Case Officer: Rebekah Morgan

Recommendation: Refuse

Proposal: Discharge of conditions 4 (archaeological written scheme of investigation) and 5 (archaeological archive report) of 23/01997/F

DRAWING TITLE: EXCAVATION TRIAL TRENCHES

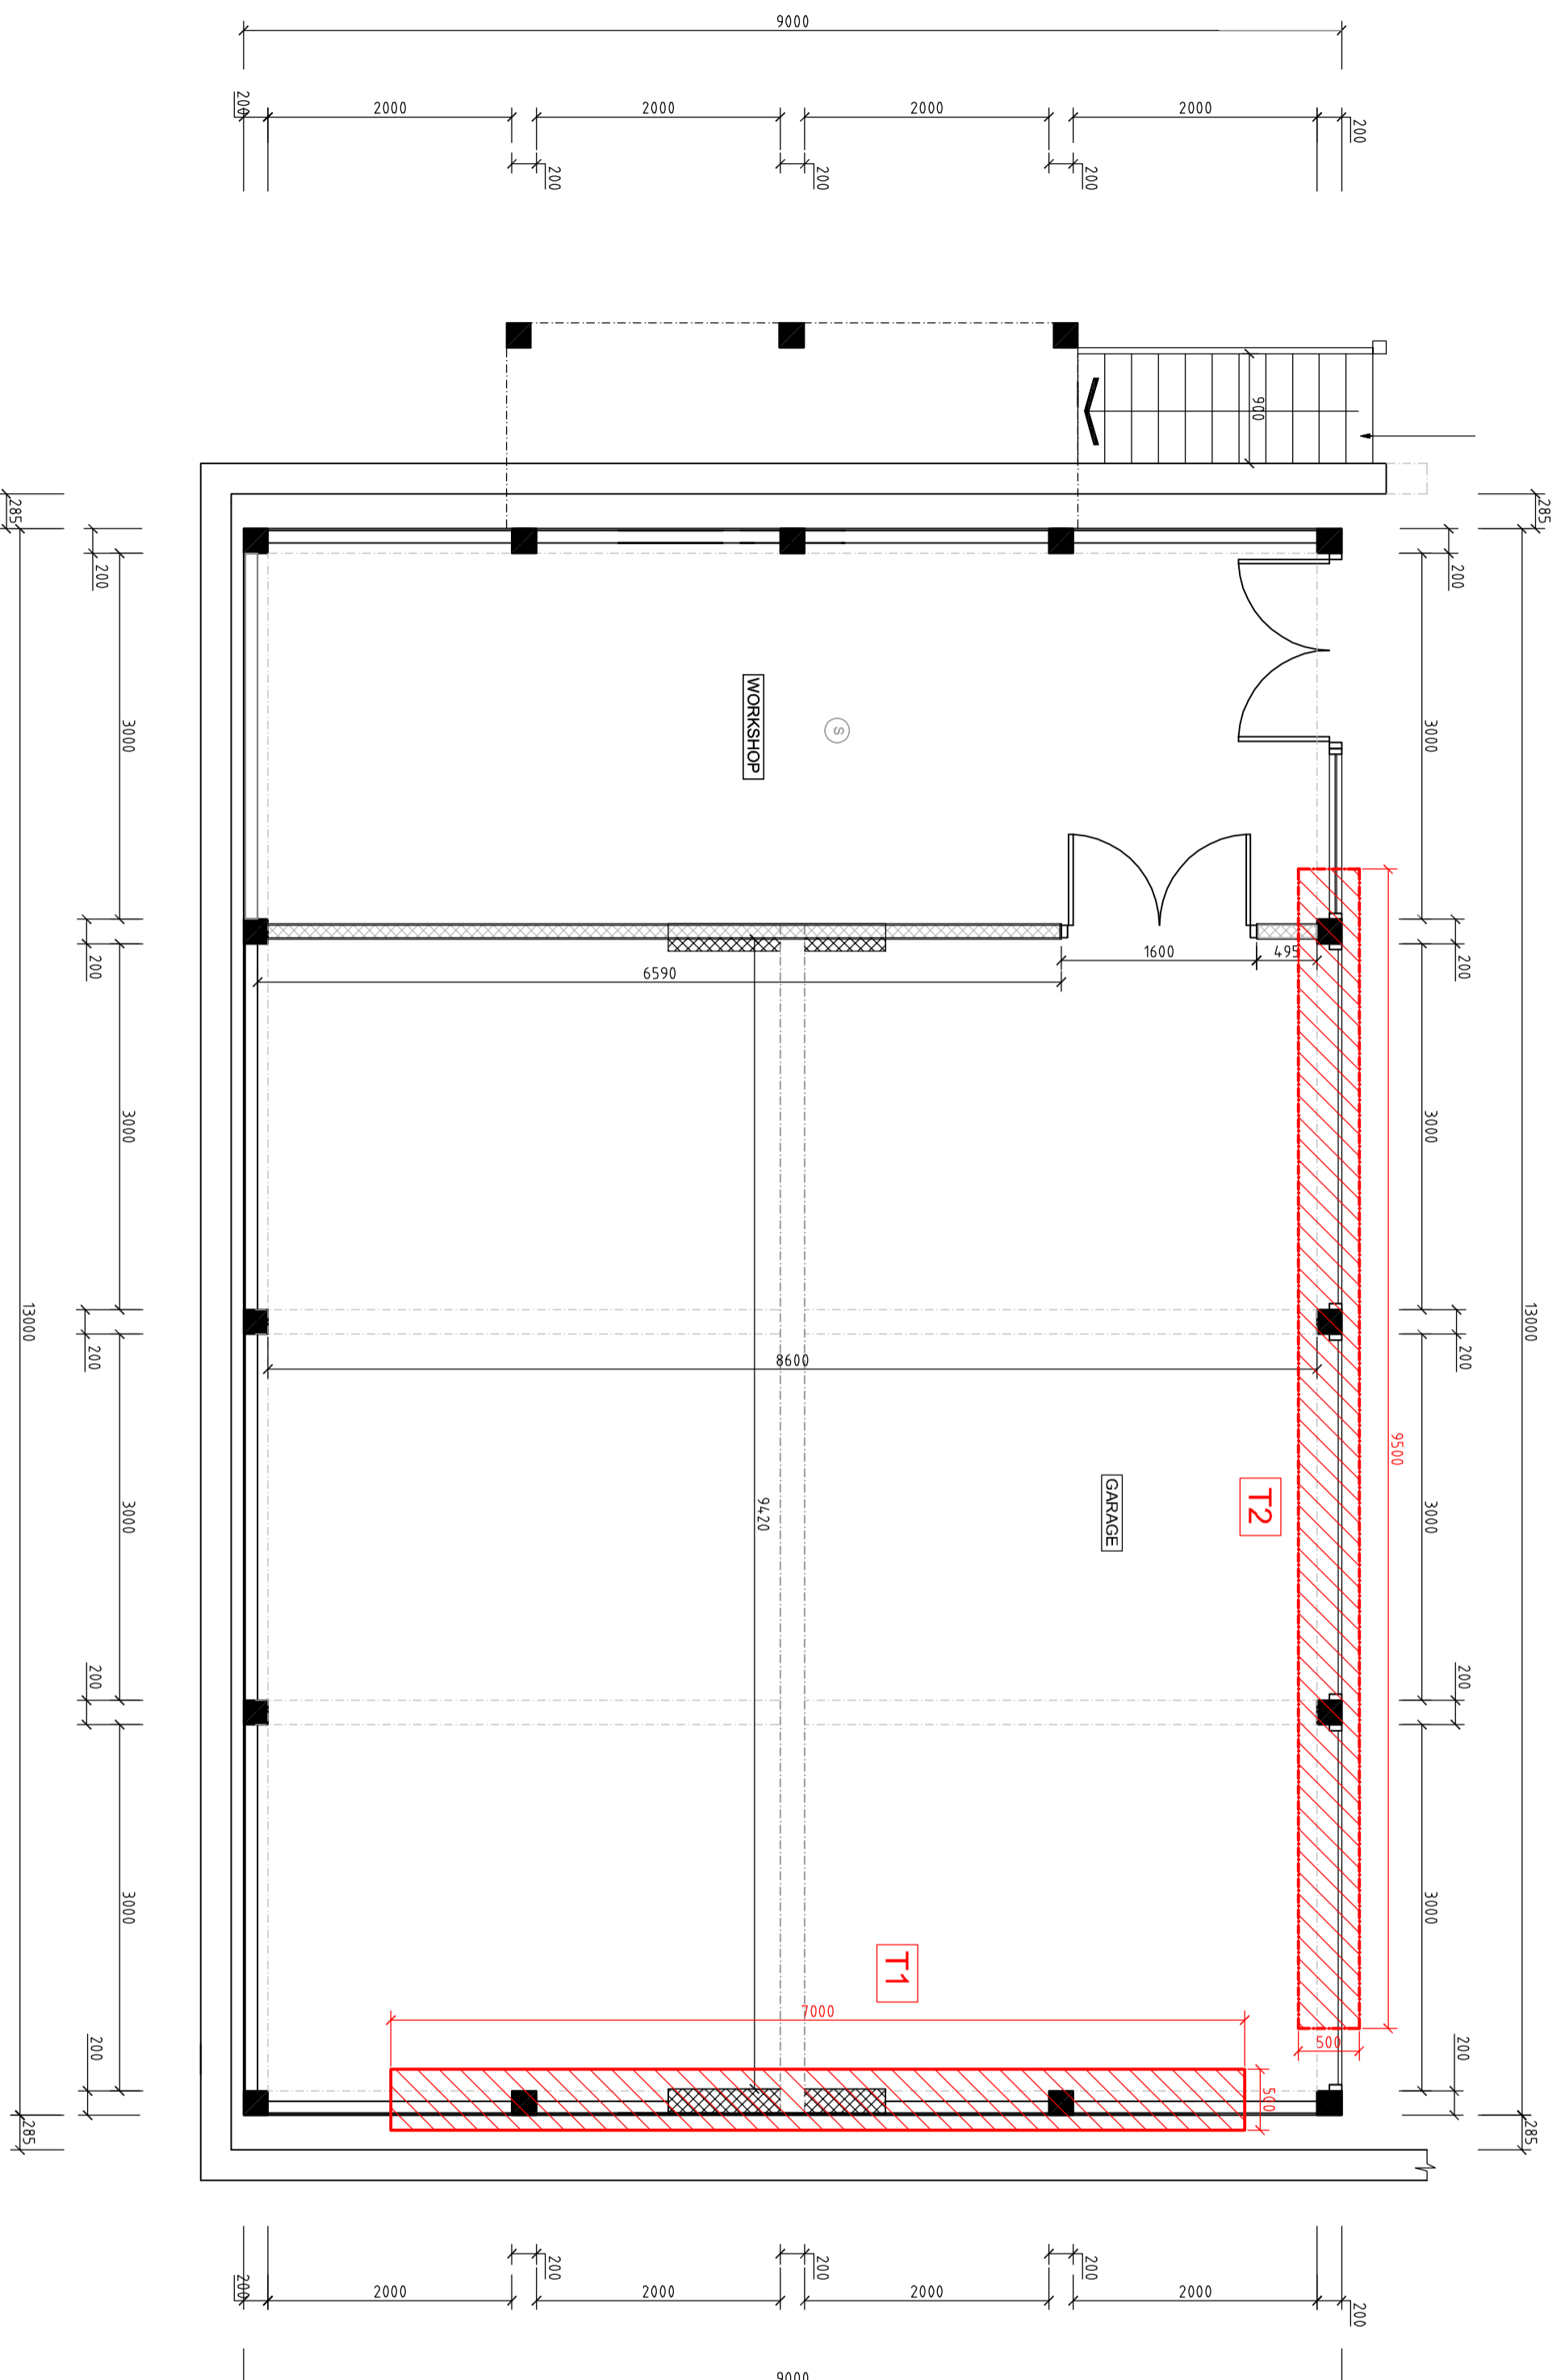
- 5.1. Condition 4 – Oxfordshire County Council's archaeologist has advised that the condition cannot be discharged. The condition requires the submission of a programme of archaeological work consisting of a written scheme of investigation and a timetable for that work. The submitted Written Scheme of Investigation is not sufficient.

The submitted Written Scheme of Investigation does not contain the required information and is therefore insufficient to discharge the condition. The applicant is required to contact Oxfordshire County Council's Archaeologist to agree a design brief before commissioning an appropriate qualified archaeologist to produce the Written Scheme of Investigation, including a timetable for the works.

The applicant should contact Oxfordshire County Council's Archaeologist to for further advice. They will outline the required procedures involved, provide a brief upon which a costed specification can be based, and provide a list of archaeological contractors working in the area.
